**TO:** Jean Fraser, Planner  
**FROM:** David Senus, P.E. & Ashley Auger, E.I.T.  
**DATE:** November 13, 2012  
**RE:** 165 Presumpscot Street, Final Level II Site Plan Application

Woodard & Curran has reviewed the Response to Comments on the Final Level II Site Plan Application for the proposed improvements at 165 Presumpscot Street in Portland, Maine. The project consists of paving an existing gravel lot (an existing impervious surface) and associated drainage improvements. The proposed paved lot falls within the footprint of the existing gravel lot, and therefore the project does not propose to increase impervious area on the site. Overall, the project proposes a net decrease of impervious area of 64,430 sq ft.

DRAWING NO.
C-31

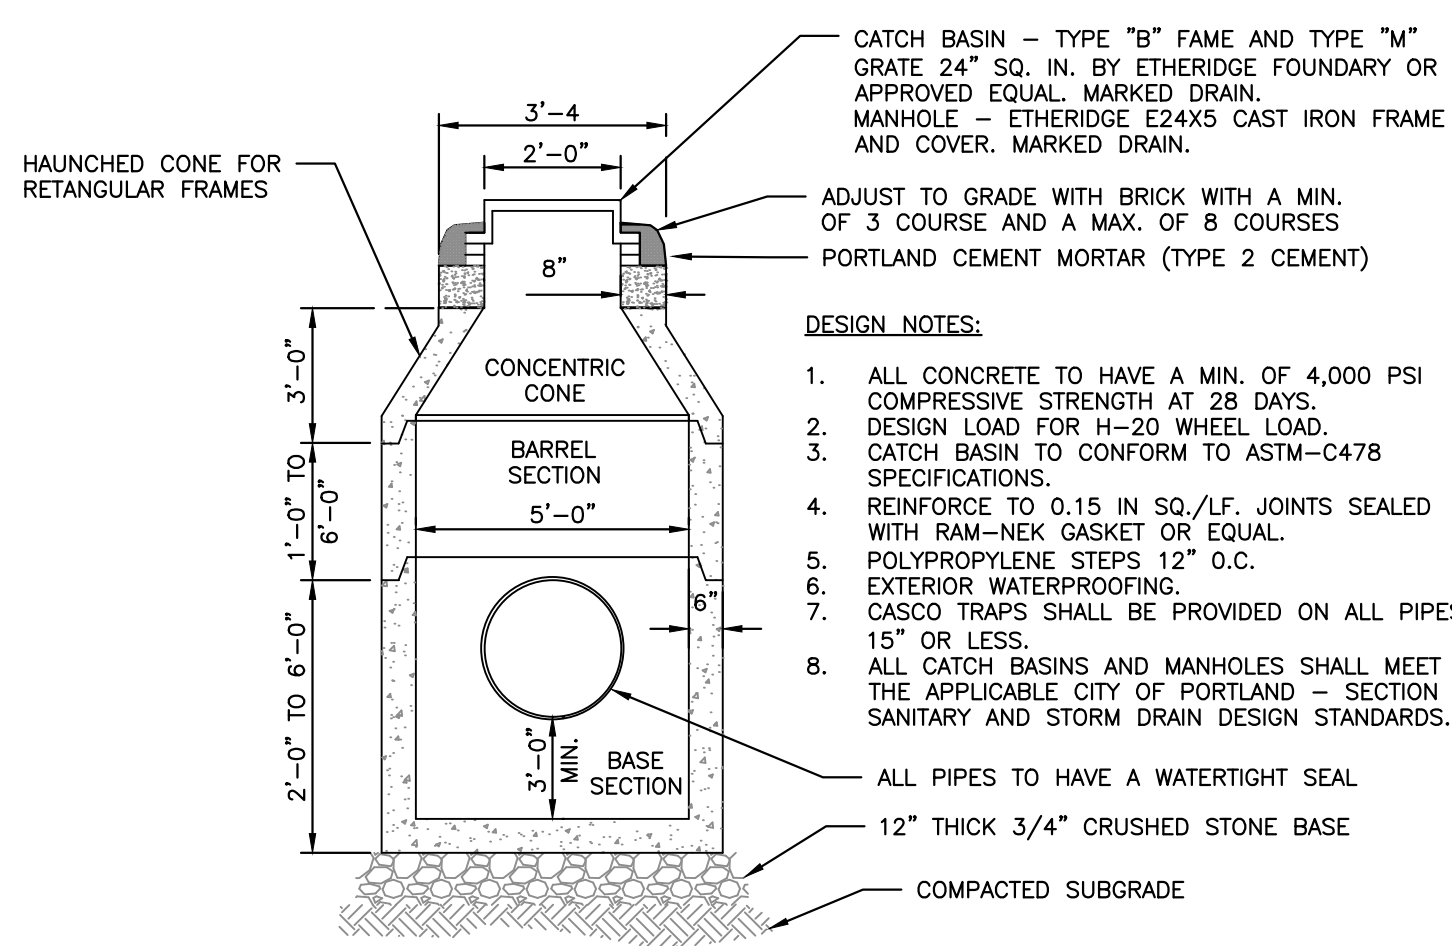
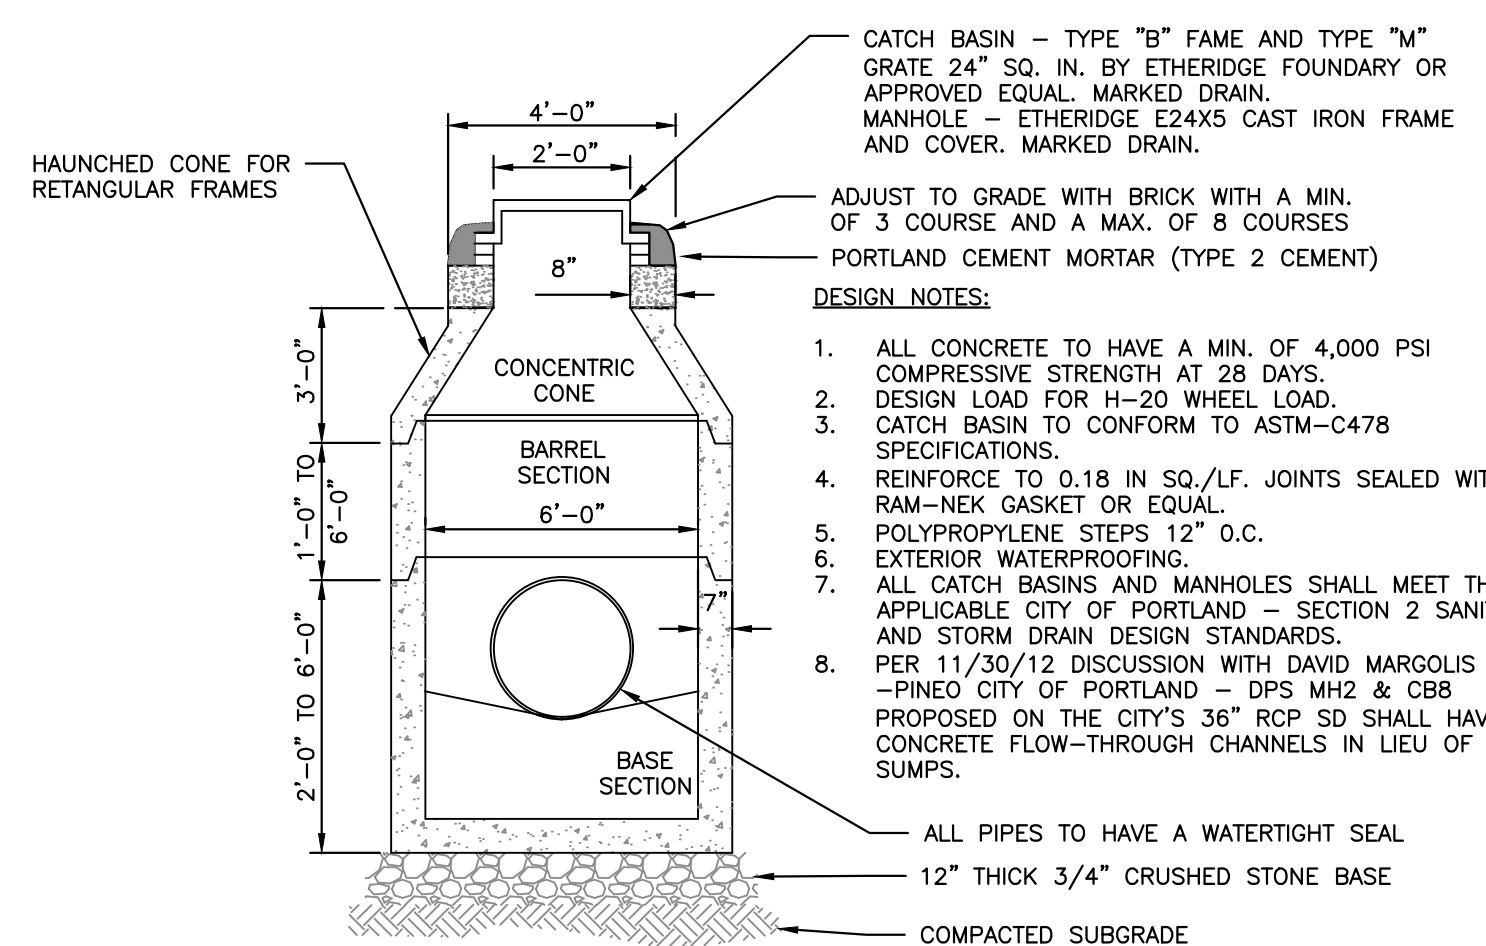
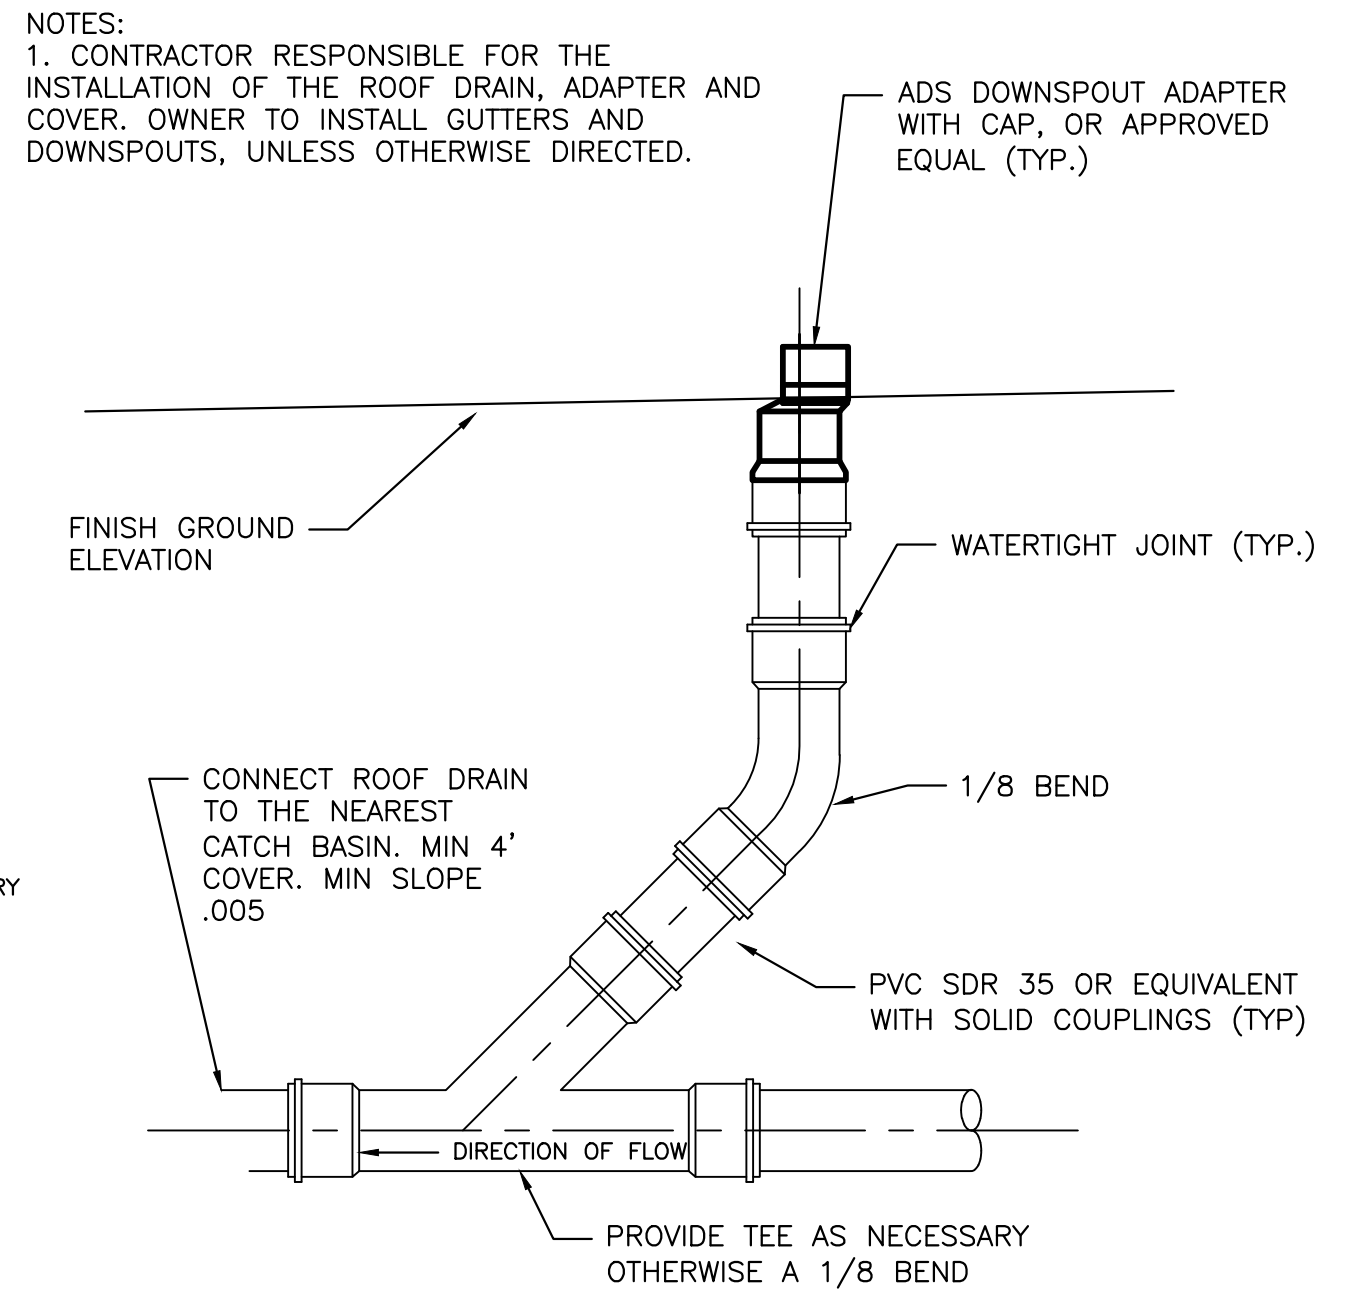
1. The Applicant has included catch basin and manhole details on Sheet C-31 which indicate 3' sump depths. These structures are acceptable for use as catch basin and manhole structures associated with the site's drainage collection system; however, MH2 & CB8 proposed on the City of Portland's 36" RCP storm drain pipe should have flow-through channels in lieu of sumps.
2. All other comments have been adequately addressed.
